January 19, 2011

RE: 67-73 Quebec Street – 014-M-013 – R-6 Zone

I am in receipt of your request for Zoning determination concerning the division of the lot located 67-73 Quebec Street into two separate lots.

1" = 20'  
 67 Quebec Street  
 14-M-13  
 8/22/2008  
 Sketch Of Proposed Lot Split  
 For Review

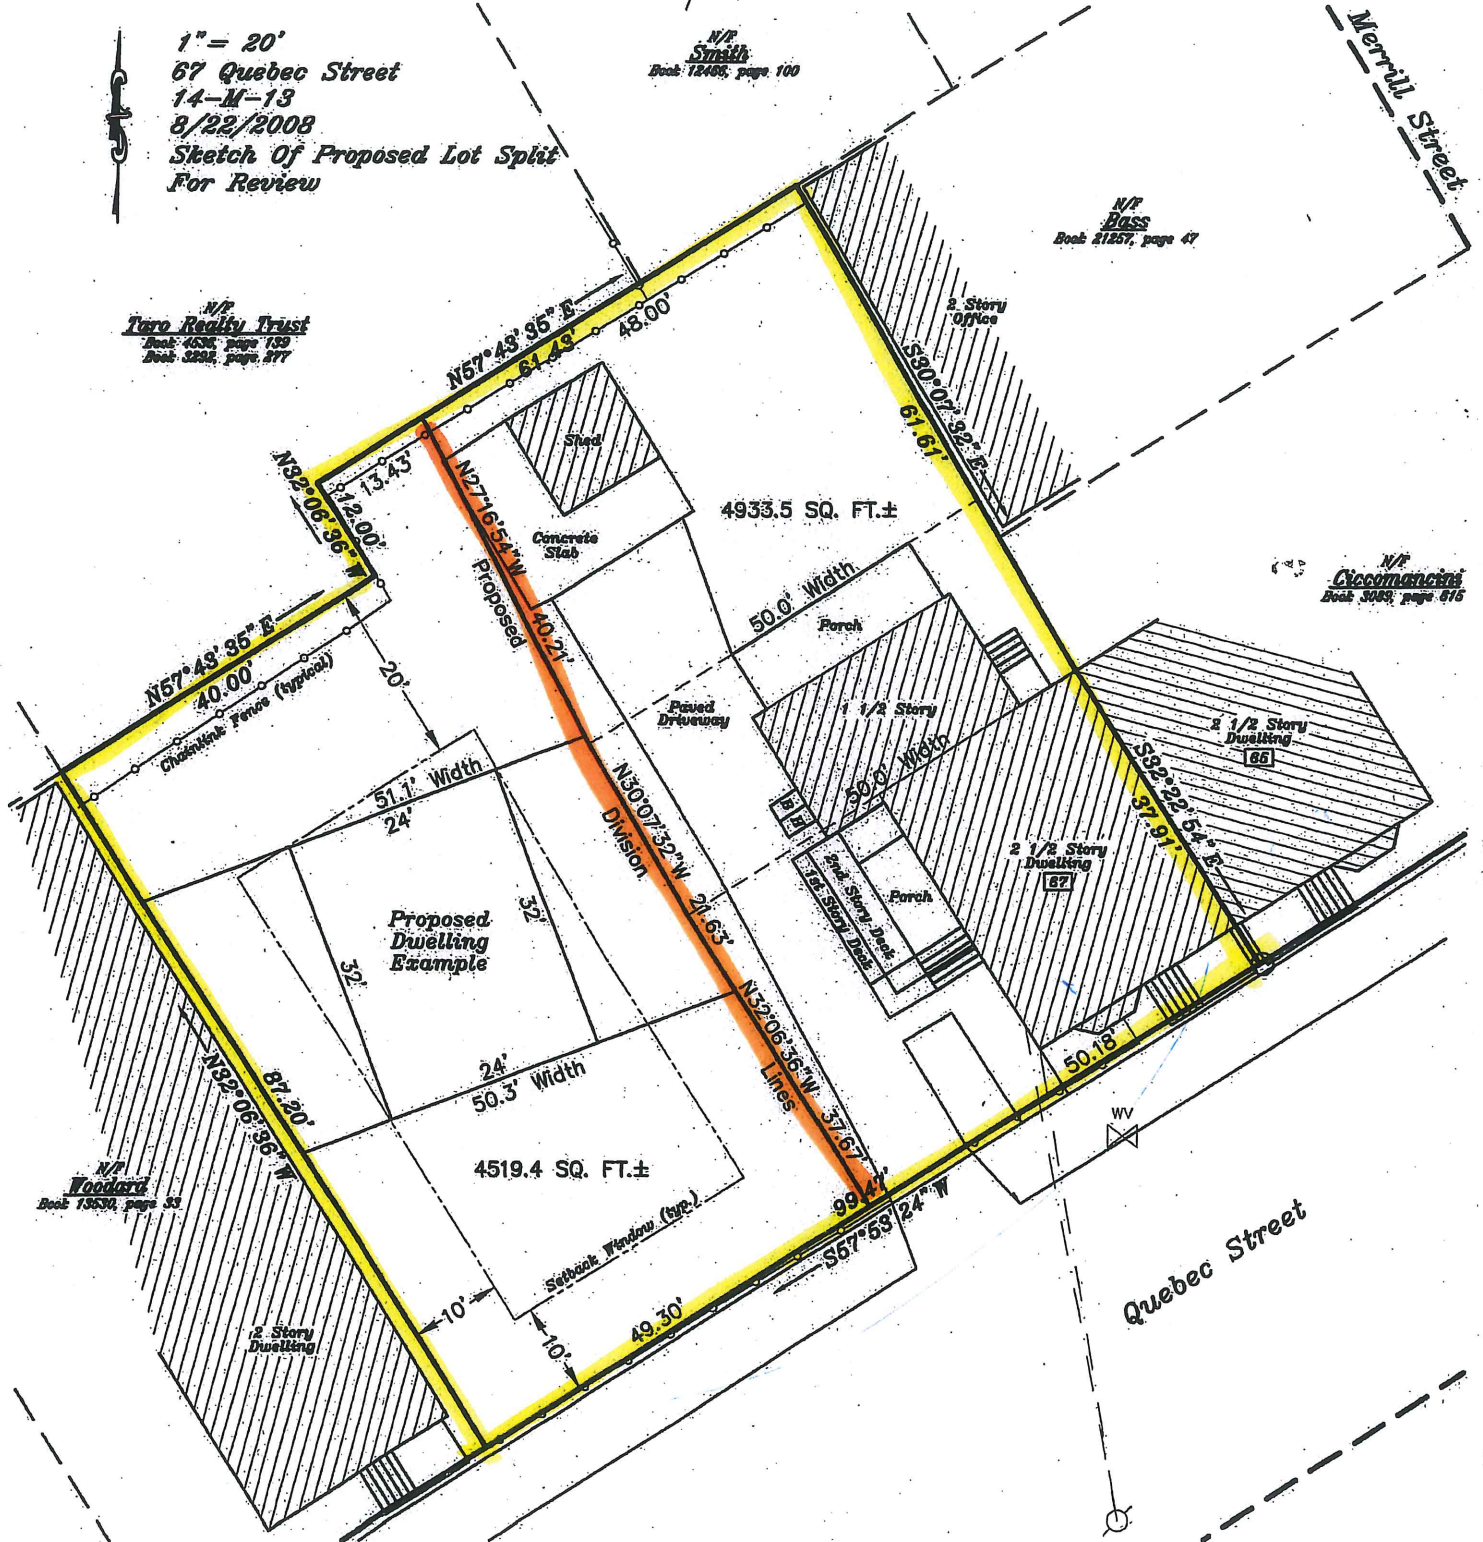
67-73 Quebec Street is located in a R-6 residential zone. My determination is based upon a preliminary survey provided by James D. Nadeau, LLC, Professional Land Surveyors. It is noted that the “survey” is not stamped and is not signed by the surveyor. I received a scaleable preliminary survey on January 11, 2011 for this review.

Base upon the preliminary survey, it is noted that two lots created by the one division of land as depicted on the submitted “survey” would meet the underlying R-6 zone requirements.

It is noted that the R-6 zone was changed in October, 2010 to allow a 40 foot minimum lot with instead of the previous 50 foot minimum. The newly created vacant lot from the division of land meets the minimum required lot width.

Your request included a comment on the “envelope” shown on the submittal. The Zoning Ordinance does not have the terminology concerning “envelopes”. What is shown on the submittal does show the allowable setbacks denoted in the R-6 zone. The R-6 zone also contains maximum lot coverage and open space requirements. What is depicted on the sketch of the vacant lot does not necessarily allow the entire area of the “envelope” to be developed. The sketch does indicate that a building can be erected on the vacant lot that can meet all R-6 zoning requirements. A final determination for a building permit can only be rendered at the time of a full permit submittal.

Please note that this determination is based upon a preliminary survey sketch which is unsigned and unstamped. When a permit application to build upon this lot is submitted, it will be necessary to submit a full, signed and stamped survey. If the final, complete survey differs from the sketch submitted at this time, my determination may not stand.
